DECISION DELEGATED TO HEAD OF PLANNING

Application No: H07-0989-21 **Applicant:** Mr S Kennally

Proposal: Demolition of existing single storey dwelling and erection of three single storey dwellings.

Location: Sunray 21 Hillgate Gedney Hill

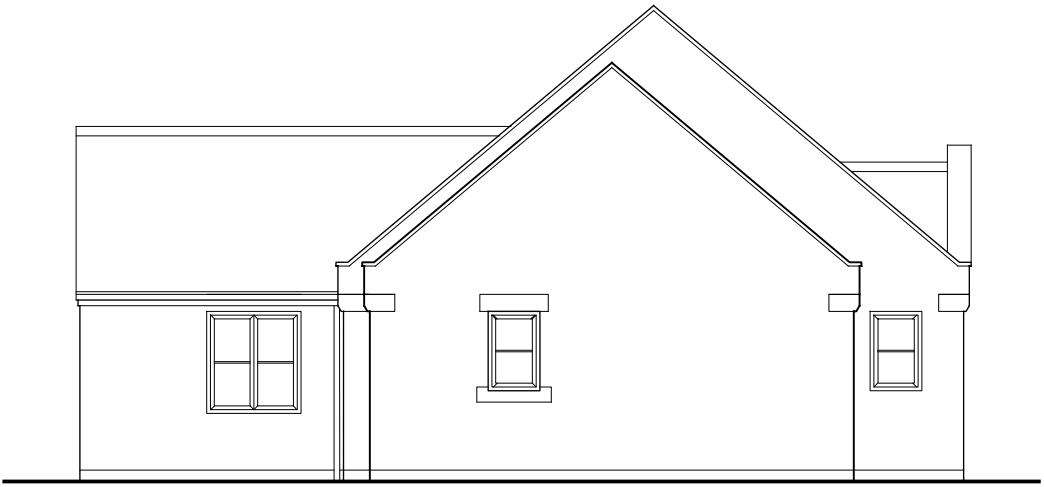
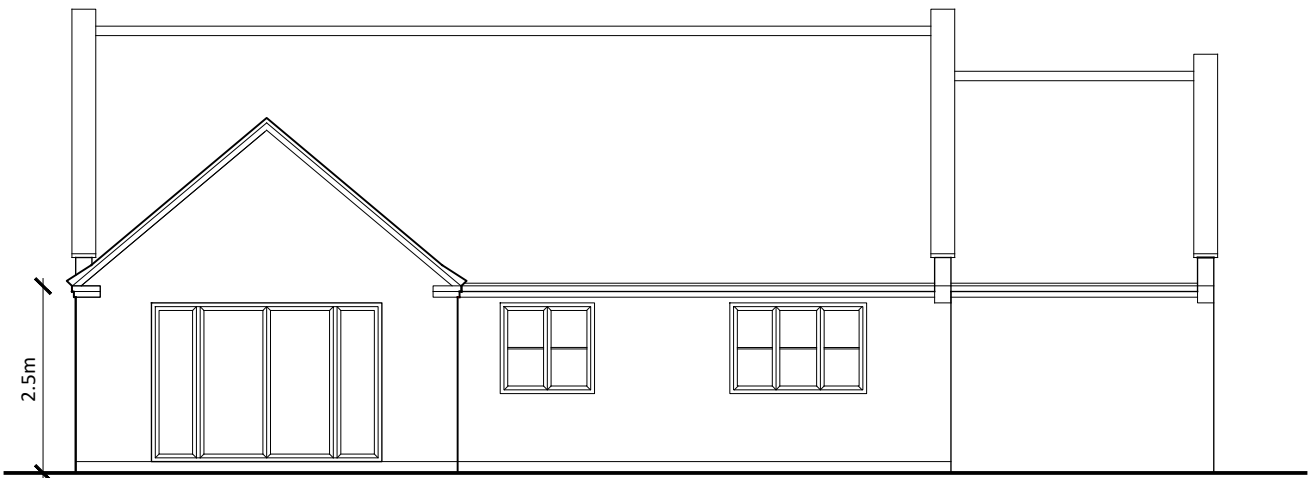
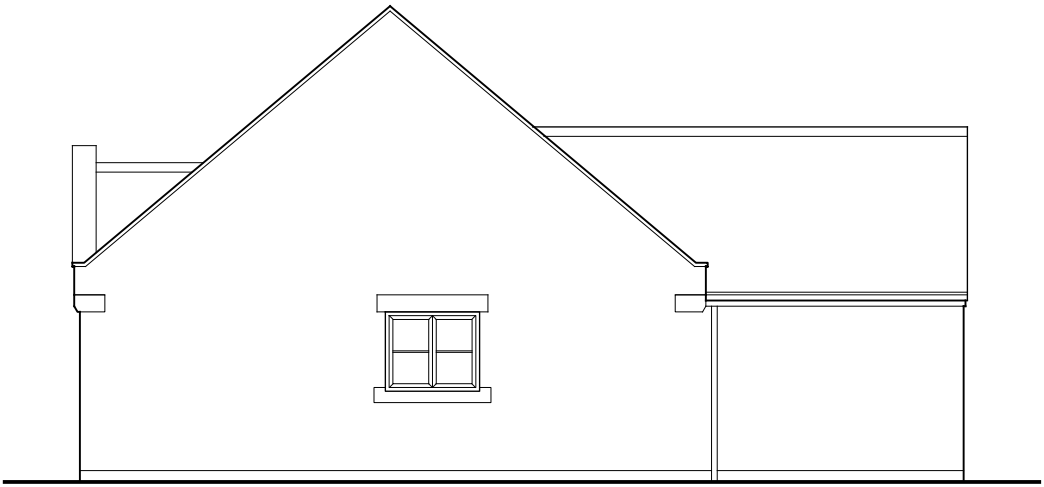
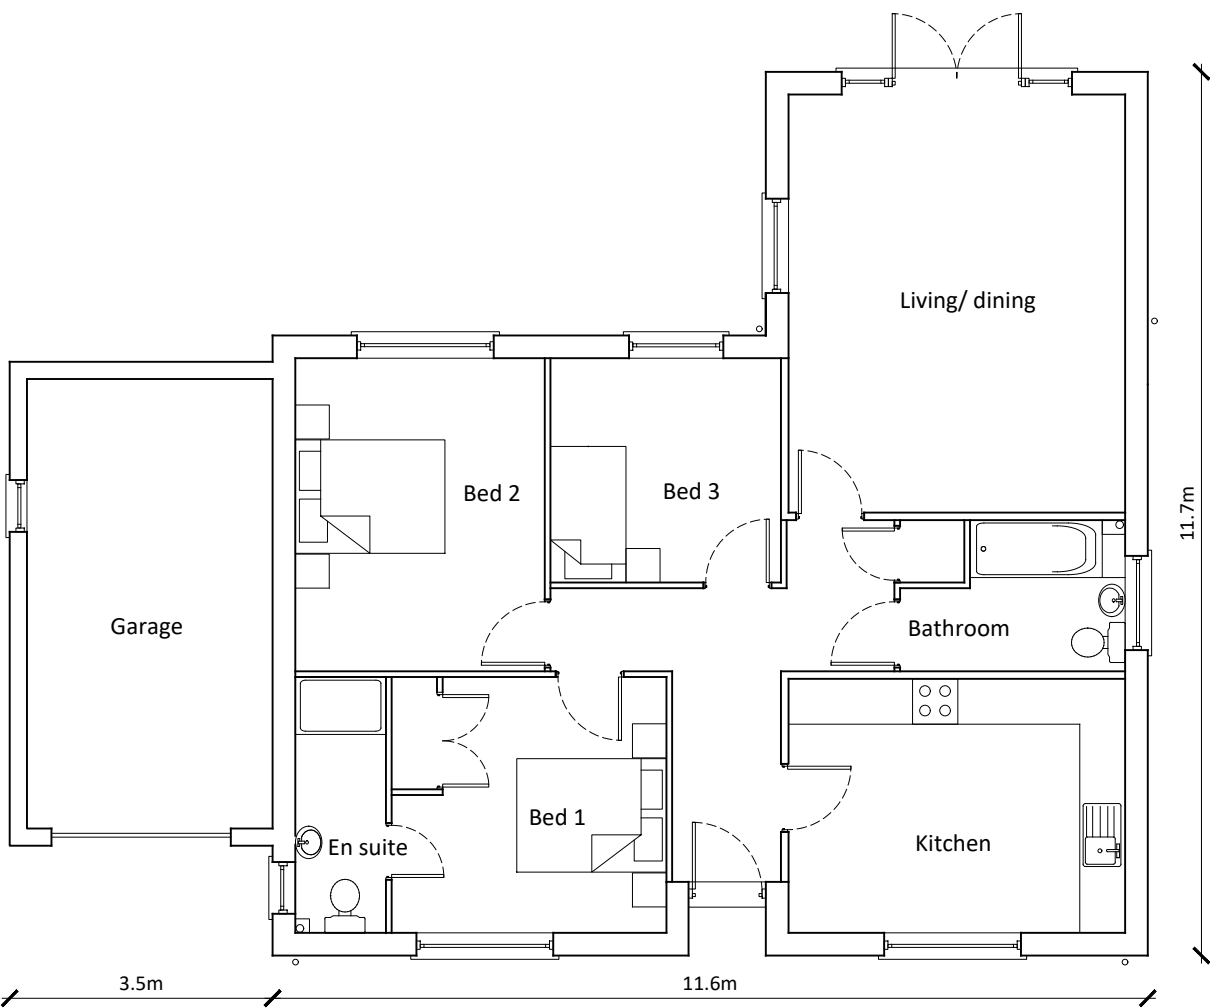
Both side boundaries are de-lineated by boundary fencing. The side elevation of the dwelling on plot 1 would be 3.1 metres from the common boundary at its nearest point and would have a bathroom window on its southern elevation. The properties on plots 2 and 3 would be further away. Although they have lounge and bedroom windows on their southern elevation the amenity of No. 23 to the south would be protected by boundary fencing.

**Drawing**  
House Type B (Plot 2)

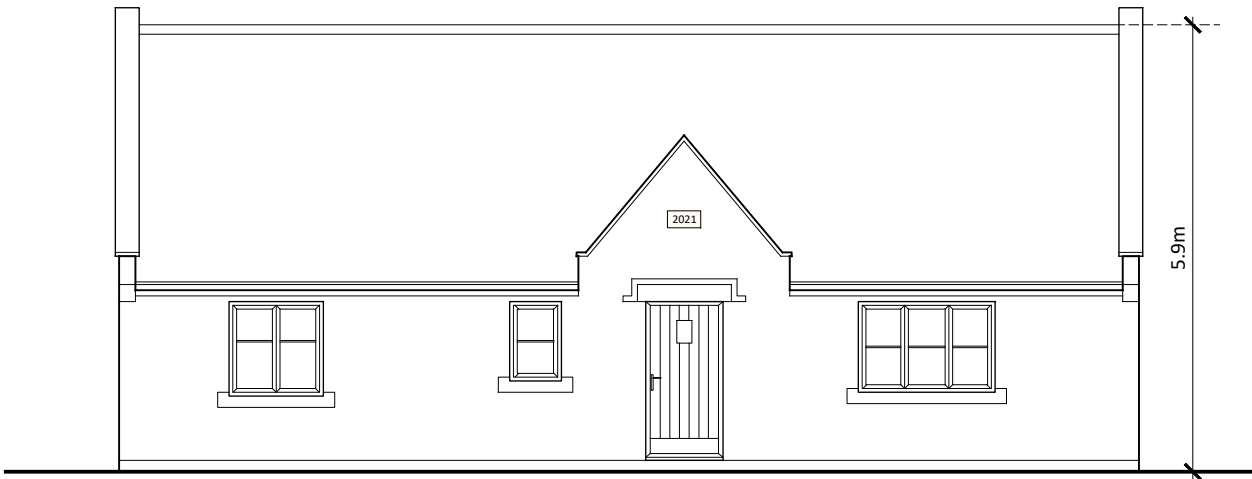
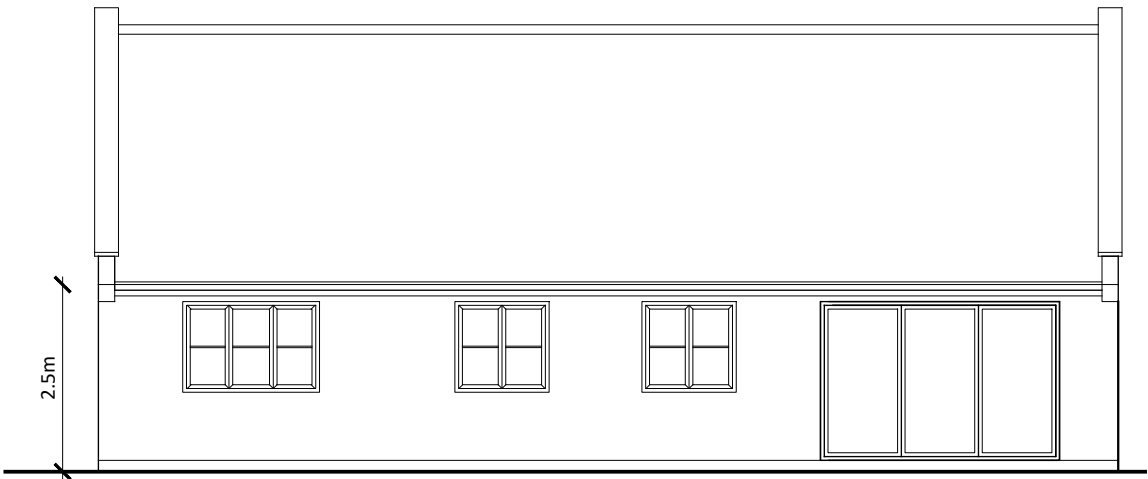
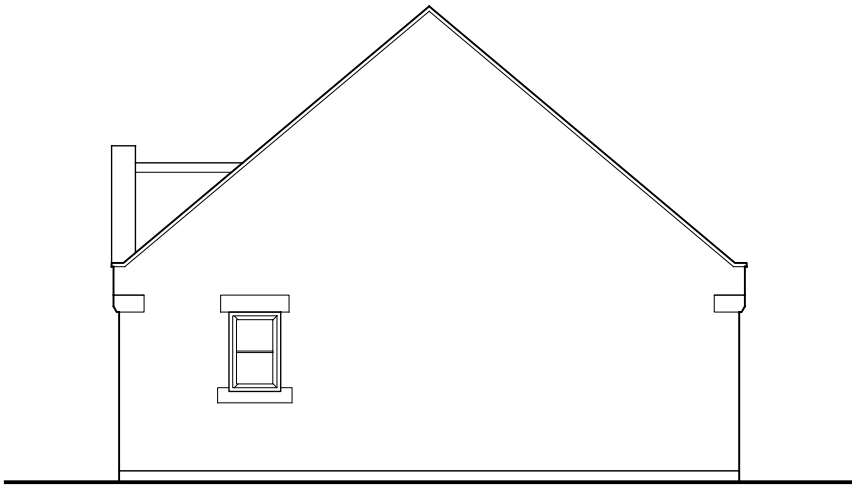
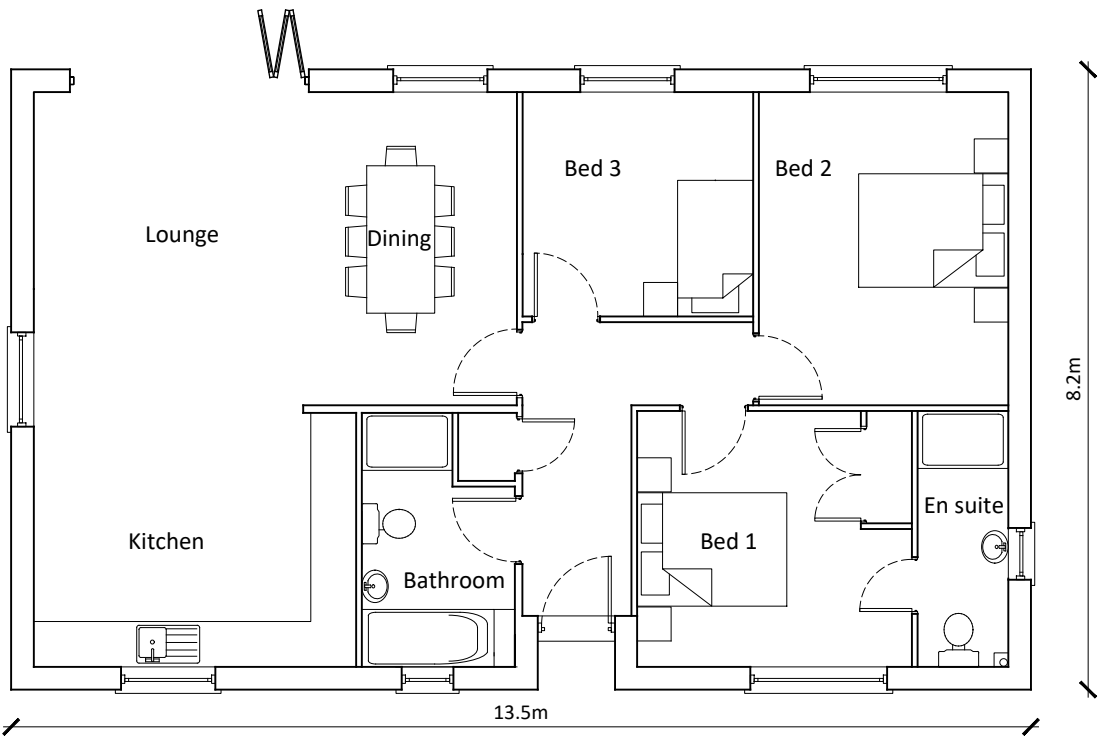
The bungalows on plots 2 and 3 have kitchen, bathroom and bedrooms on their front elevations and are approximately 12 metres from the bungalows on the opposite side of the private roadway. The separation distances are considered satisfactory in this case.

Drawing
Proposed Site Plan

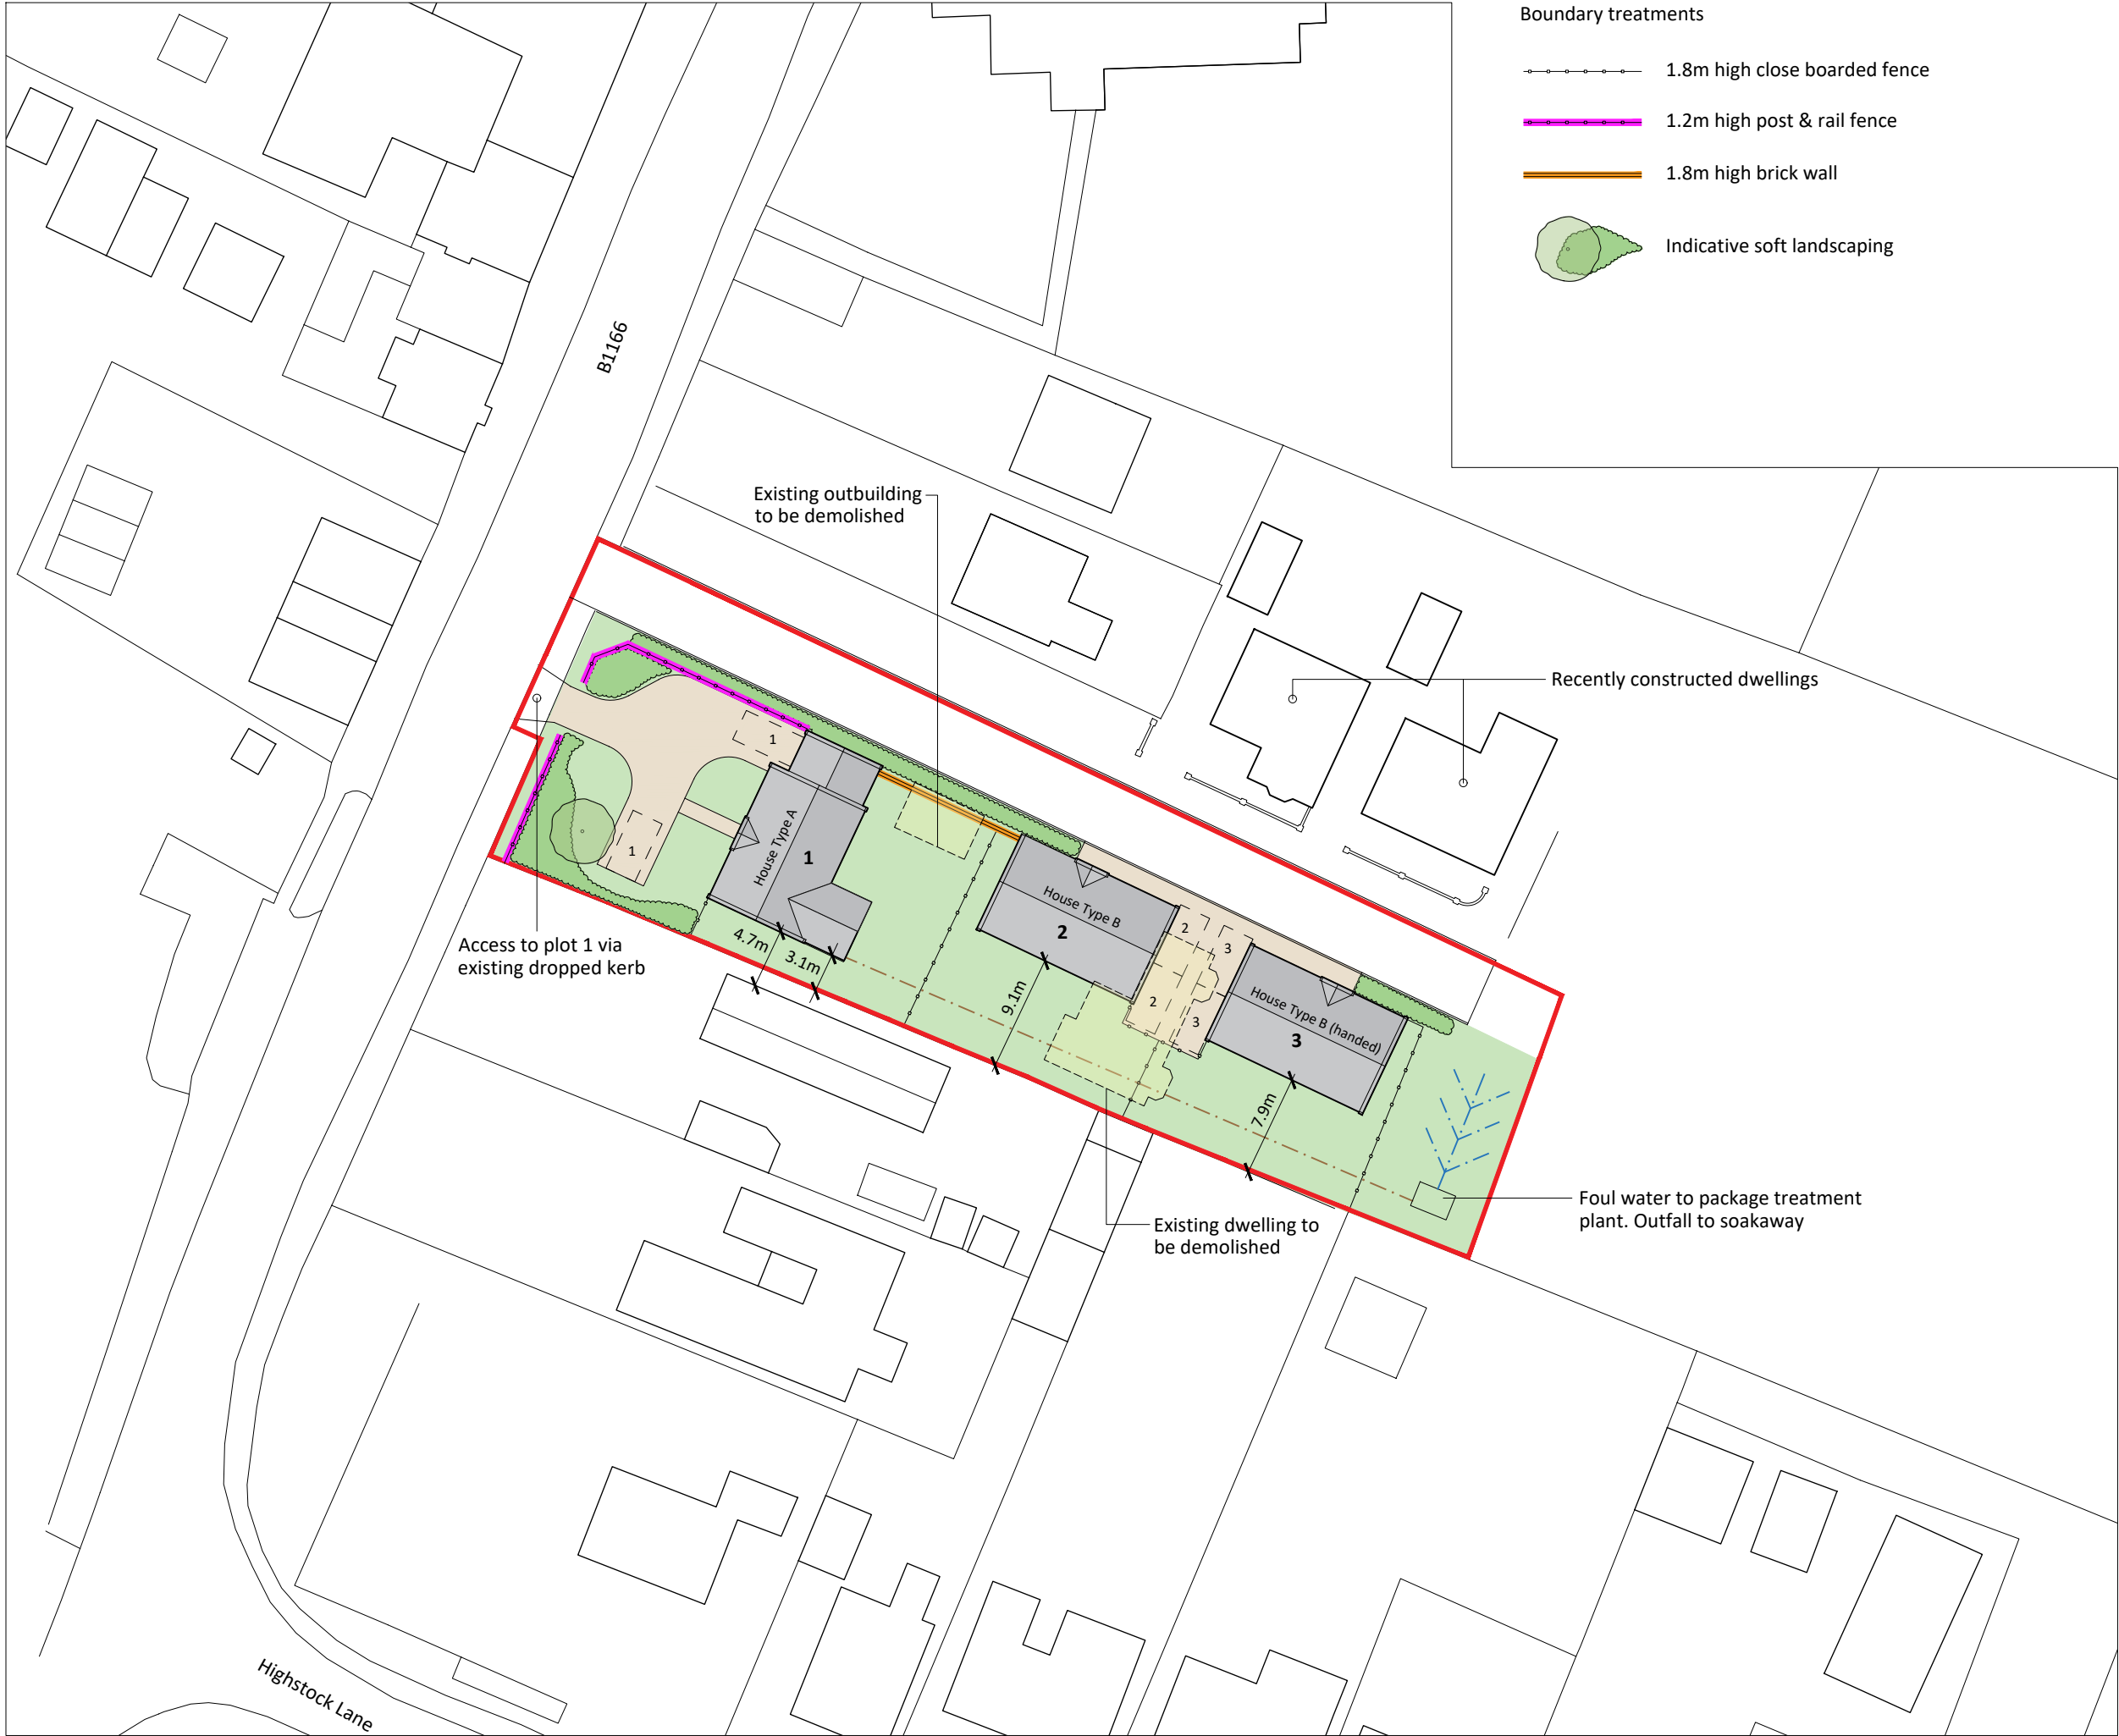
Each plot includes two parking spaces within its curtilage. The County Highways Authority does not wish to restrict the grant of permission on highway safety grounds. The proposal therefore satisfactorily complies with Policies 2, 3 and 36 of the SELLP in terms of highway safety/parking requirements.
